**Consultation Response from KC,  
Highways Development Management****2023/93704 land northwest of, Urban Terrace, Denby Lane, Grange Moor, Huddersfield, WF4  
4EB****Erection of 12 dwellings and associated works****Date Responded: 14/02/2025****Responding Officer: Ryan Kinder****Responding Ref:K16-6/38**

2023/93704 land northwest of, Urban Terrace, Denby Lane, Grange Moor

RECOMMENDATION: No objection subject to conditions.

1 Proposed Site Layout

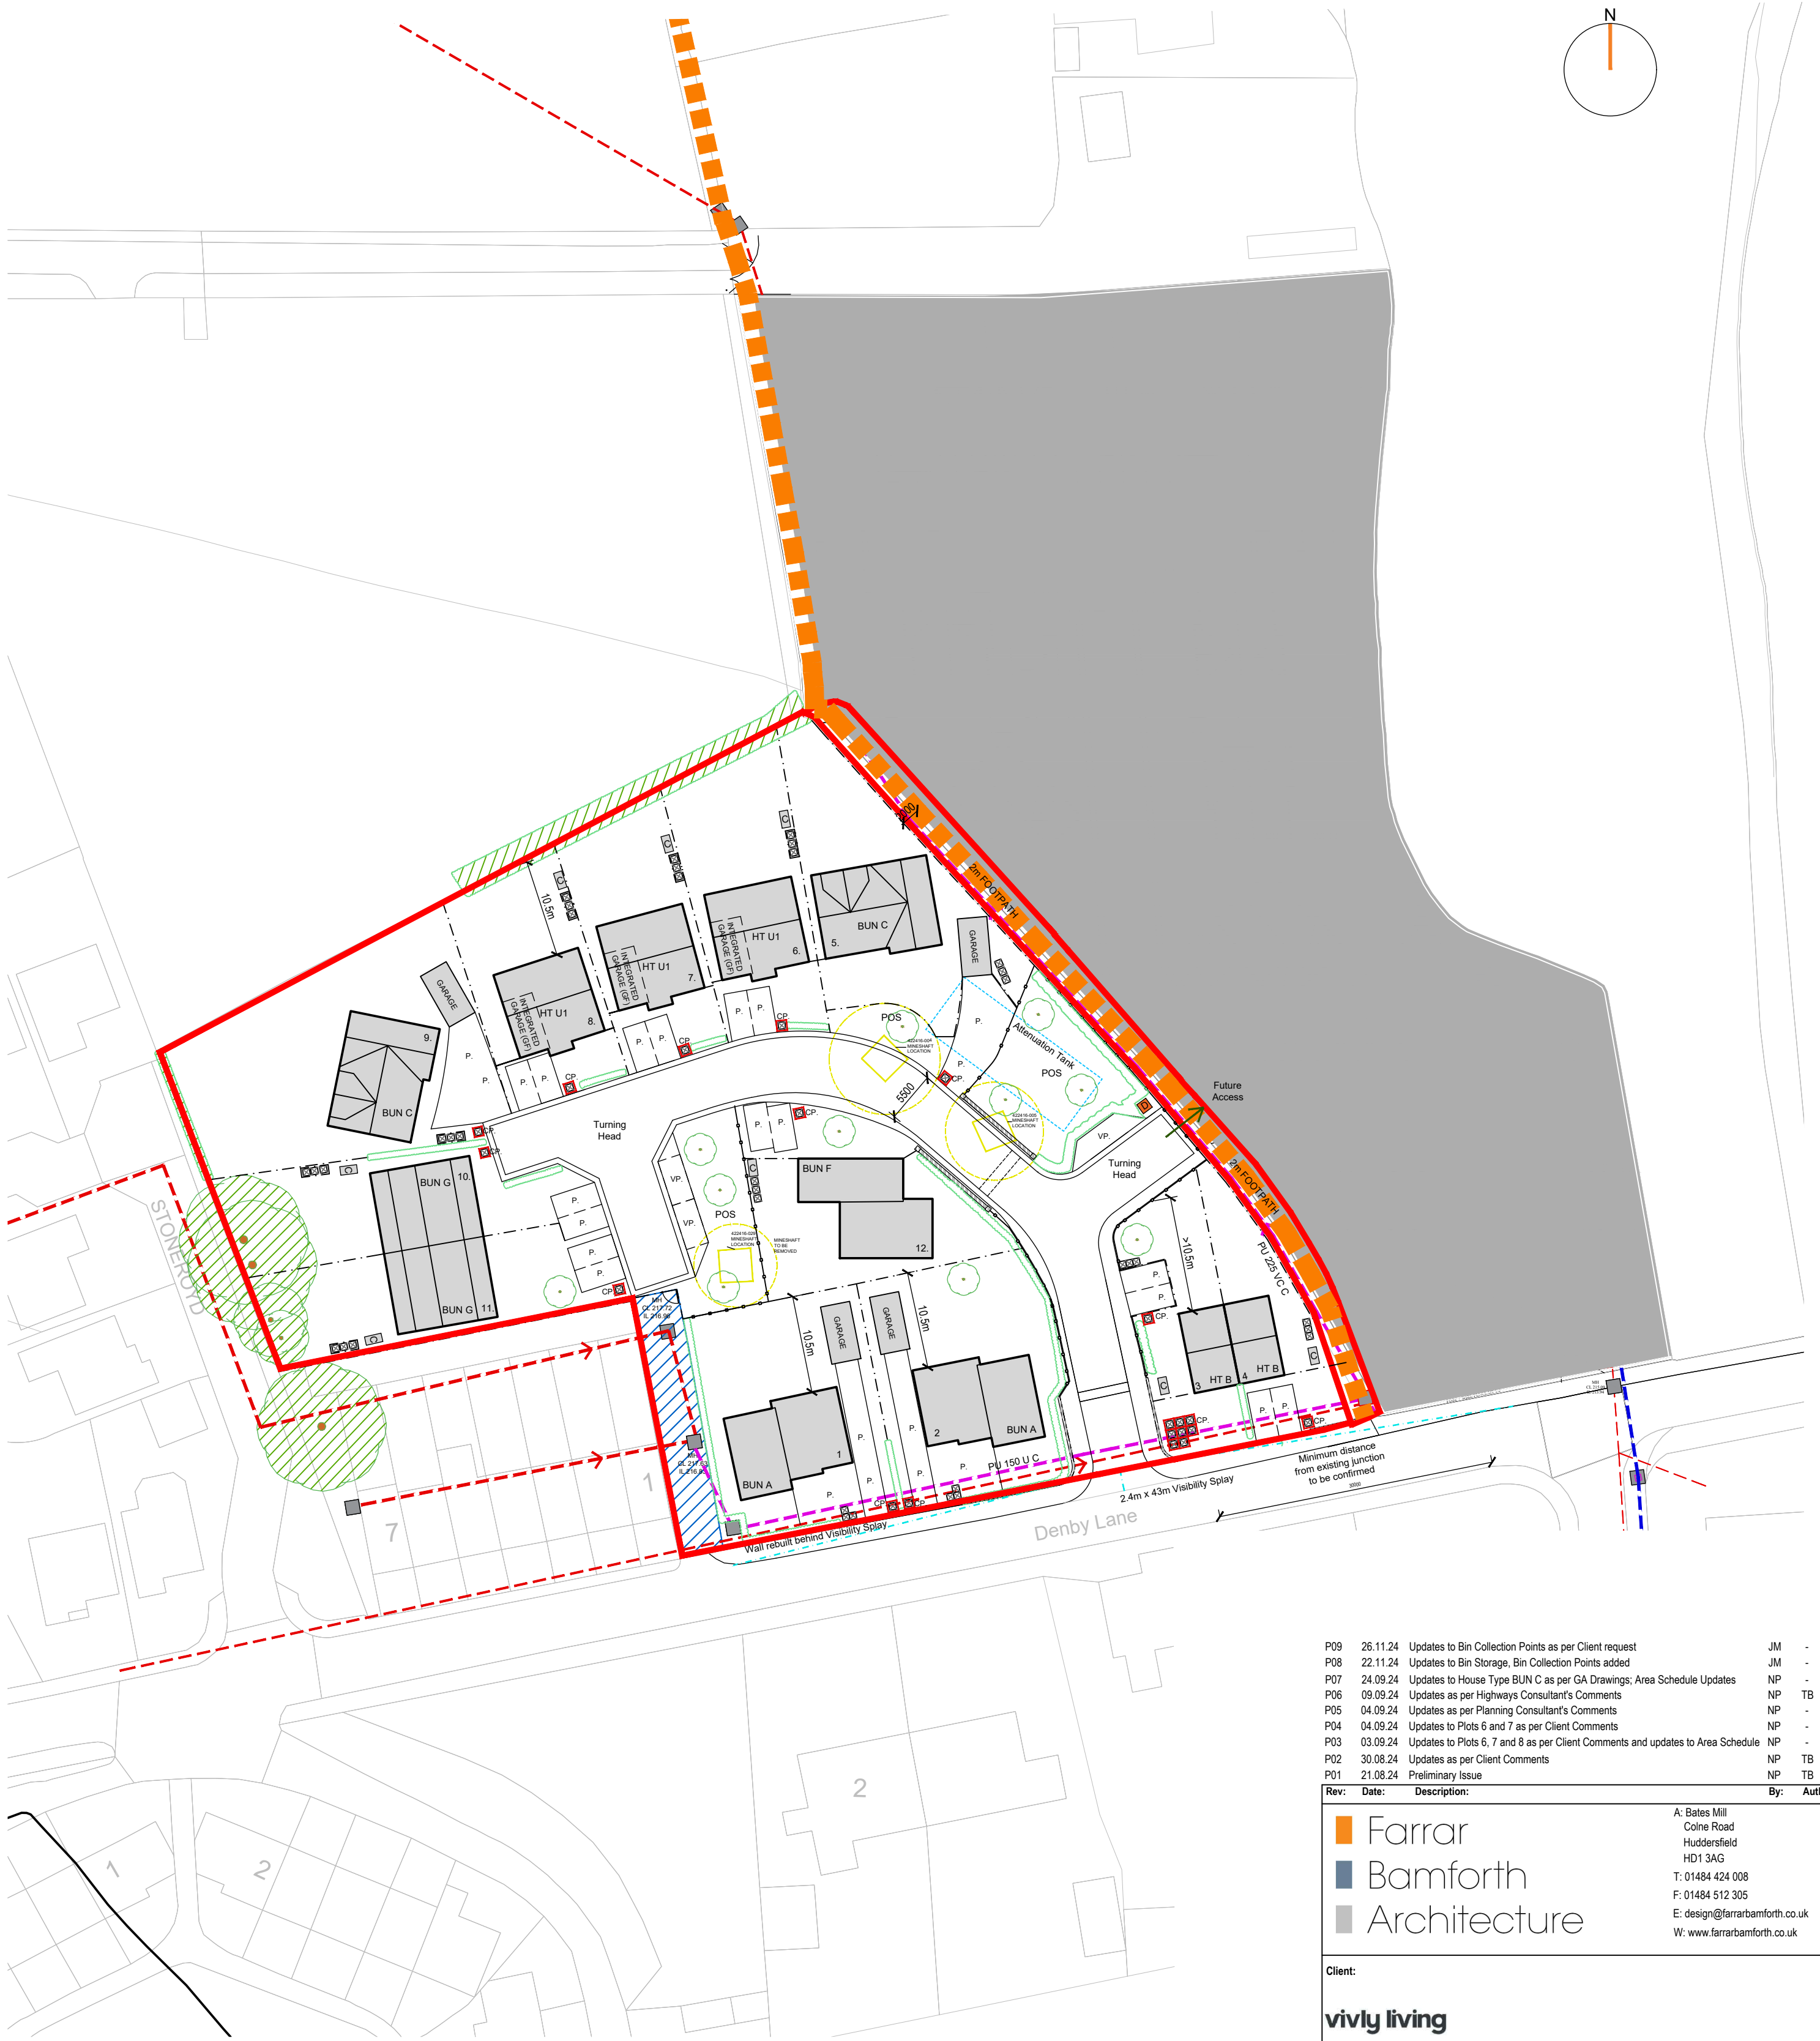
Before development commences, any obstruction shall be set back to the rear of the proposed visibility splays as shown on approved plan number 22D26-FBA-ZZ-XX-DR-A-0719-P09 and shall be cleared of all obstructions to visibility and tarmac surfaced to current standards in accordance with details that have previously been approved in writing by the Local Planning Authority.

The development shall not be first occupied until a footway 2.0m metres wide has been provided along the site frontage as shown on plan no 22D26-FBA-ZZ-XX-DR-A-0719-P09, in accordance with details which have been submitted to and approved in writing by the Local Planning Authority. The footway so approved shall thereafter be retained.

Means of access to and from the site shall be in accordance with the preliminary access design(s) as shown on the approved plan ref. 22D26-FBA-ZZ-XX-DR-A-0719-P09 and fully constructed and made operational prior to first occupation of the development and thereafter retained and maintained for the lifetime of the development.

It is proposed to access the site via one existing singular point of access off Denby Lane which is adopted, Suitable visibility splays have been demonstrated of 2.4m x 43m and will be secured via condition.

KEY

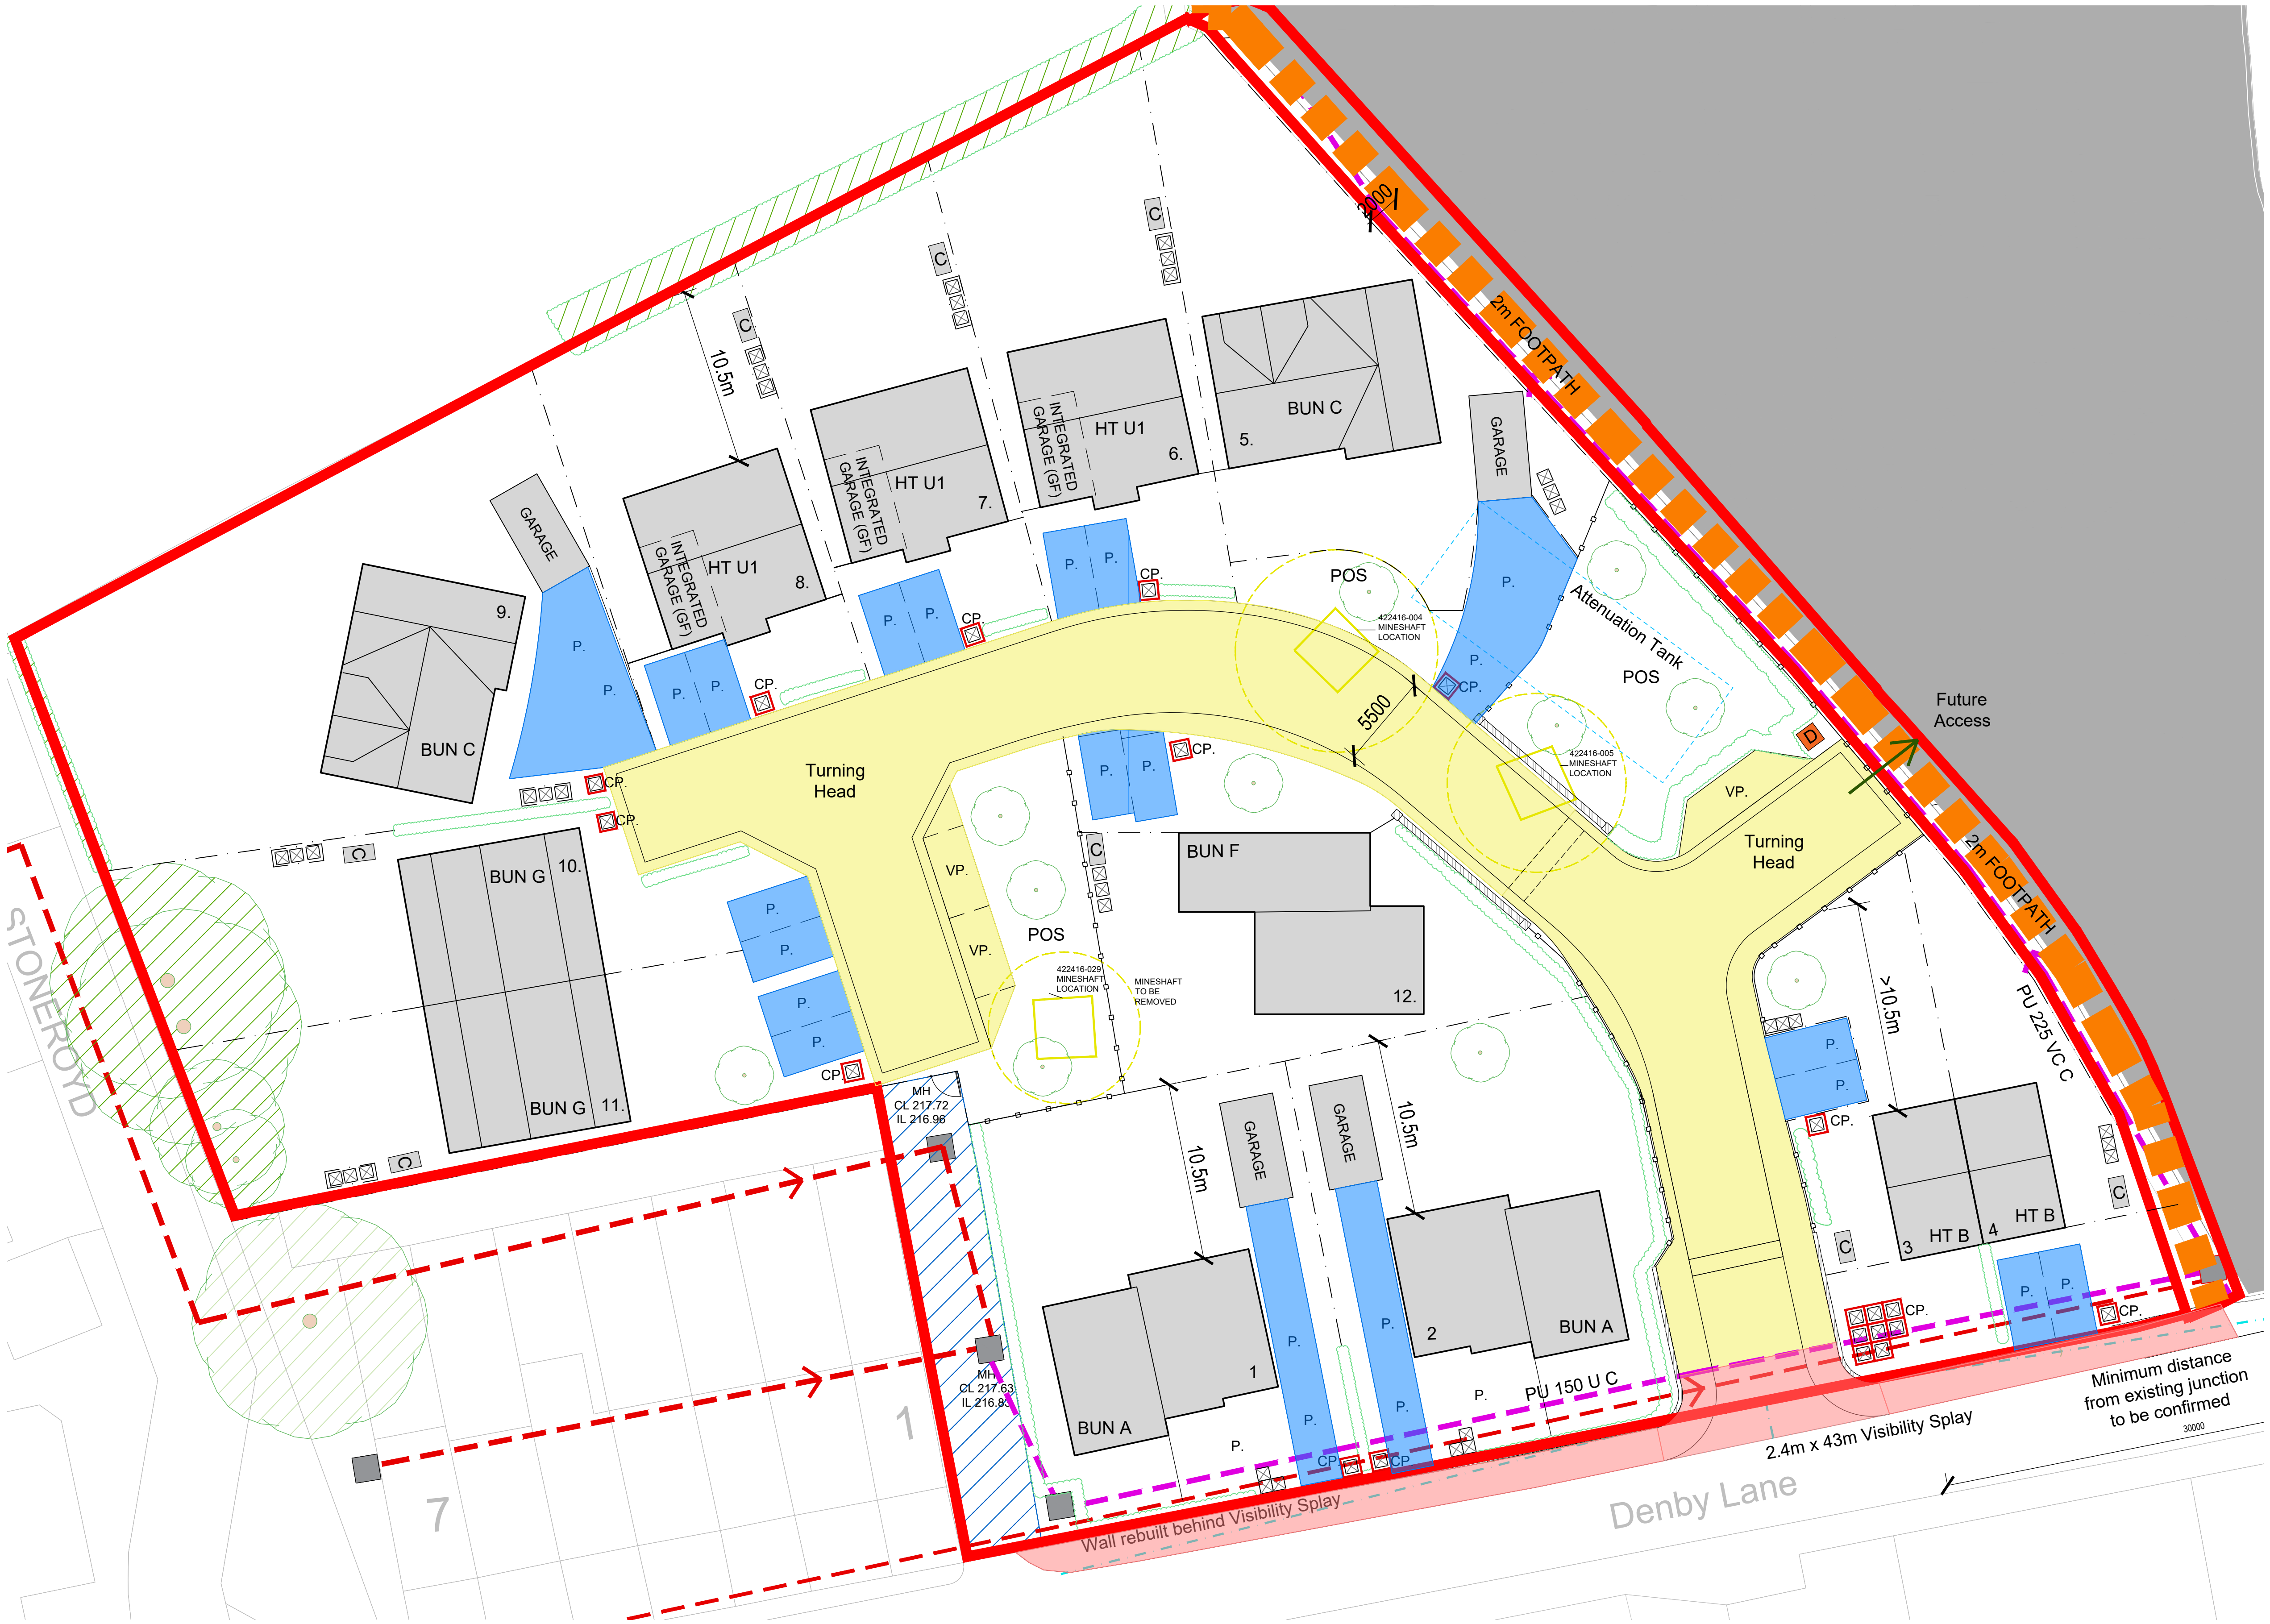
The internal layout is not to be offered for adoption as indicated on the submitted highway areas plan (ref 22D26-FBA-ZZ-XX-DR-A-0750- REV 03), whilst the Councils refuse collection team may enter the unadopted road to collect refuse from each dwelling, if this is not the case then as a fall back position a refuse collection point has been indicated adjacent to Denby Lane. This may require residents to present bins for collection at this location on bin collection days.

A plan detailing the intended area for adoption or to remain private is requested, this 'Highways Area Plan' plan will form part of the approved planning documentation, should amendments be required in terms of the areas to be adopted etc if planning is approved then a section 73 application will be required to vary this. An example of the requirements of this plan can be obtained by contacting me direct.
